**KIRKLEES METROPOLITAN COUNCIL
INVESTMENT & REGENERATION SERVICE**

Reference No: 2020/62/91234/W

Site Address: 238, Deighton Road, Deighton, Huddersfield, HD2 1JJ

Description: Erection of extensions and alterations to existing outbuilding to create dwelling forming annex accommodation associated with 238, Deighton Road, Deighton, Huddersfield, HD2 1JJ

Scale	Project
1:20 / 1:50 / 1:200 / 1:250	003

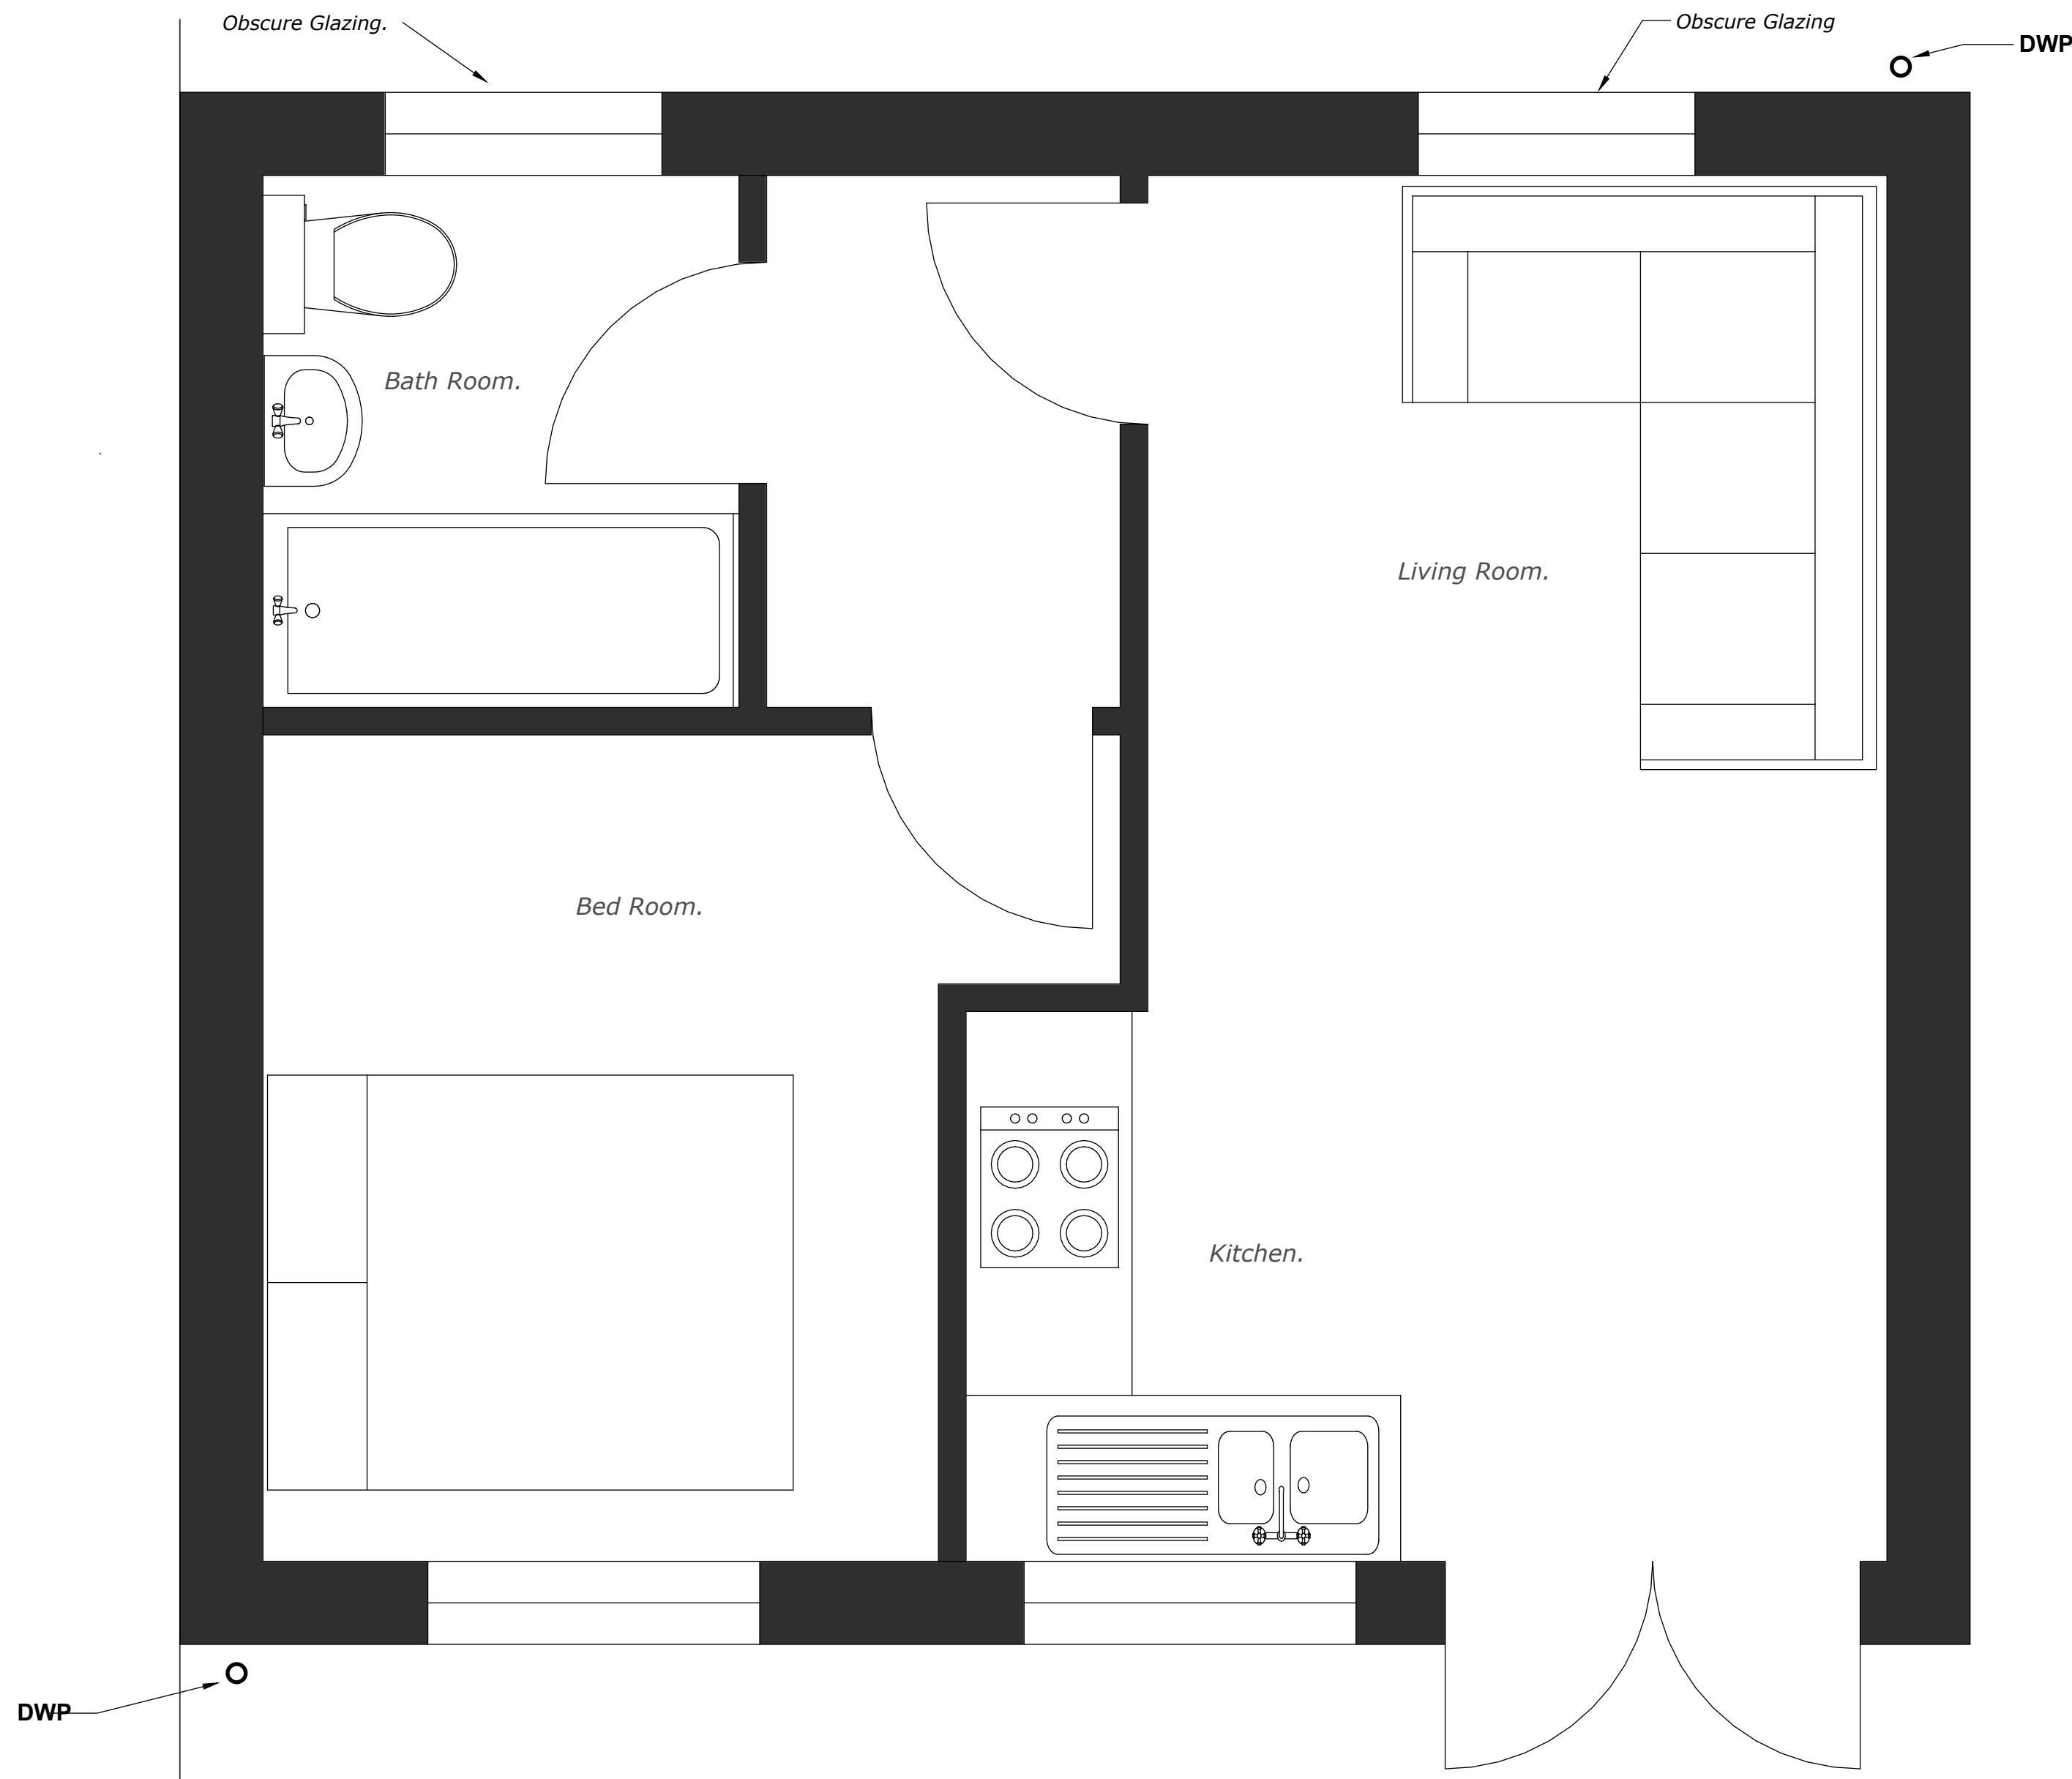
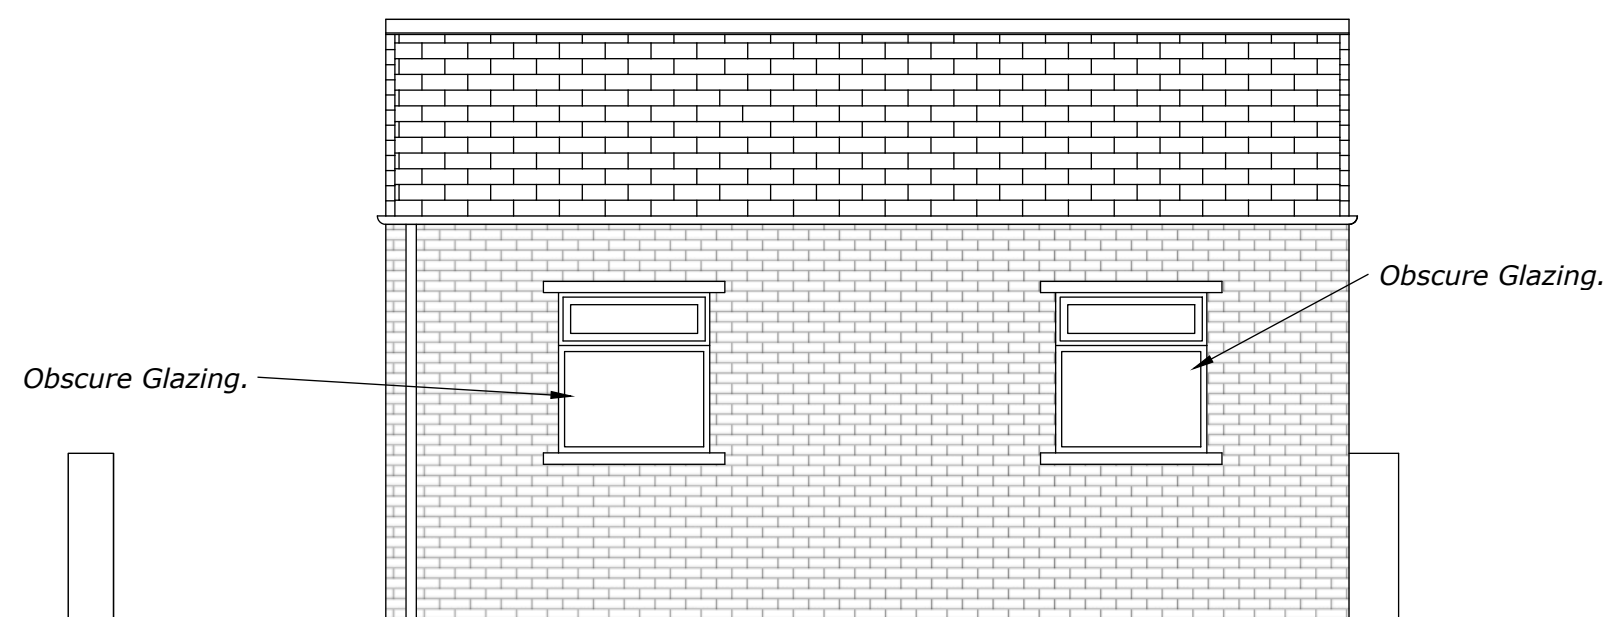
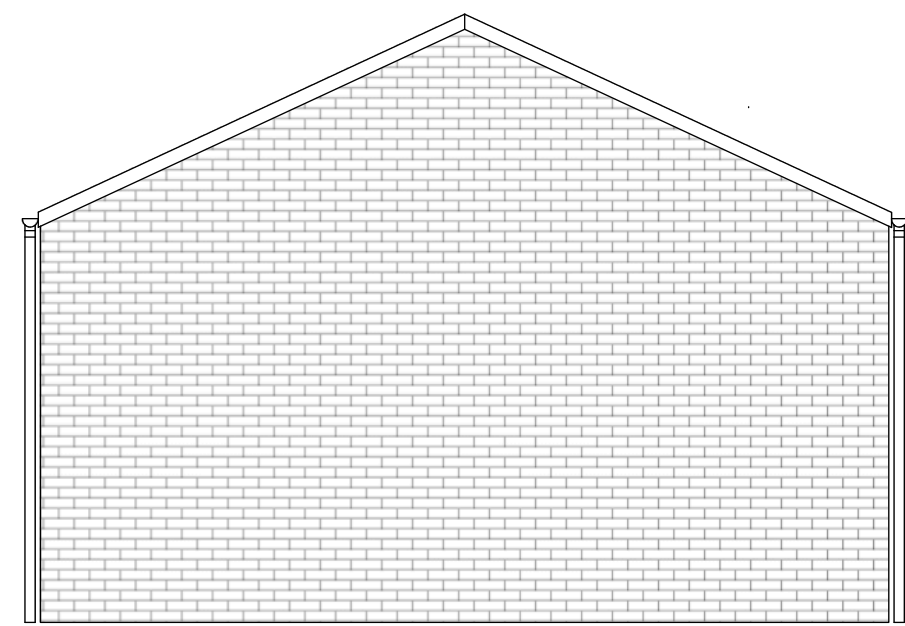
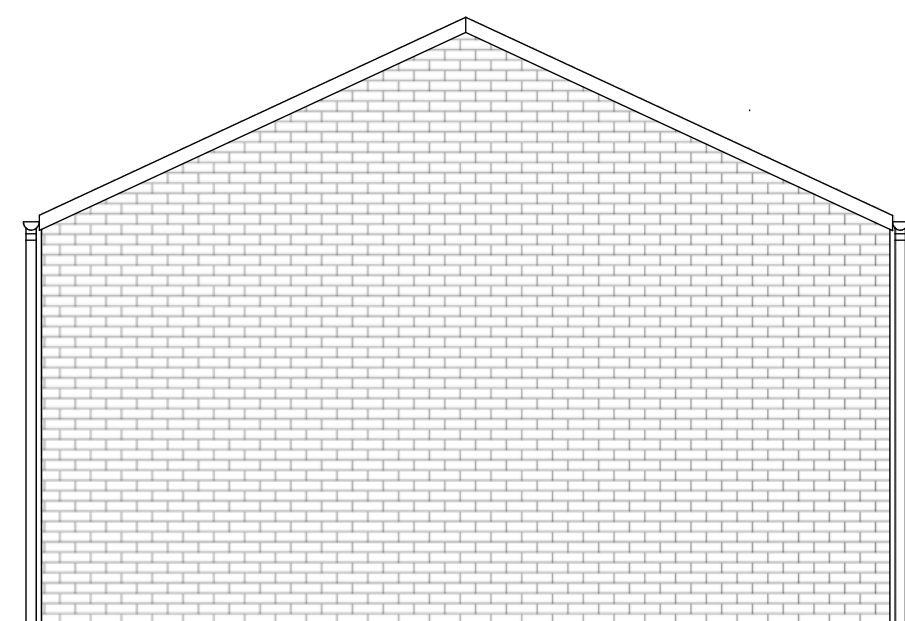
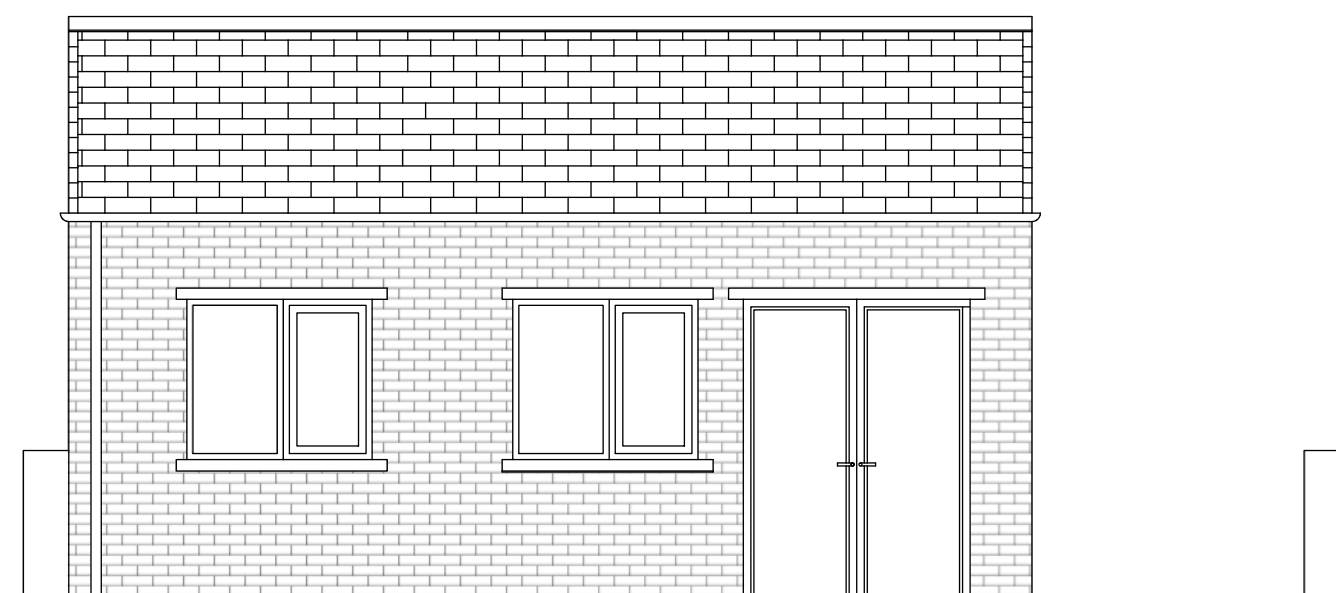
26 and 28 Wood View are the neighbouring properties to the North of the application site. It has been acknowledged that the original scheme would have an undue overbearing and overlooking impact upon these neighbour's amenity, given the close relationship between these neighbour's rear elevations. However, amendments have been sought in order to retain the footprint and overall height of the existing building and to extend it slightly to the south, towards to the host property. As a result, officers are satisfied that there would be no material overbearing and overshadowing, when compared to the existing arrangement.

The submitted plans show two openings to be inserted into the rear elevation, however, these will be obscurely glazed to serve a W.C and a secondary opening to the living area. This will retain these neighbour's amenity from any undue overlooking and therefore a condition will be attached to the decision notice to state that the glazing shall be a minimum of grade 4 and shall be retained for the lifetime of the development.

The plans also show no additional openings to be inserted into the eastern facing elevation, in which will help protect these neighbour's privacy. This has been considered acceptable and therefore permitted development rights for future openings within this elevation will be removed.

The plans show three new openings to be inserted into the front elevation, one to serve the bedroom and the others to serve the kitchen/diner. These may have the potential to impact upon the amenity of no. 240 Deighton Road, however, officers have noted that the openings would retain an outlook directly into the application site. As such, any potential impact could be screened by a timber fence.

The plans also show no additional openings to be inserted into the western facing elevation, in which will help protect these neighbour's privacy. This has been considered acceptable and therefore permitted development rights for future openings within this elevation will be removed.

7. The ground floor openings within the north western facing rear elevation of the annex accommodation to serve the W.C and living room, as shown on Dwg. no 003 shall be fitted with obscure glazing, minimum grade 4. Notwithstanding the provisions of section 55(2)(a)(ii) of the Town and Country Planning Act 1990 and the Town and Country Planning (General Permitted Development) (England) Order 2015 (or any Order revoking or re-enacting that Order with or without modification) the windows shall thereafter be so retained obscure glazed.
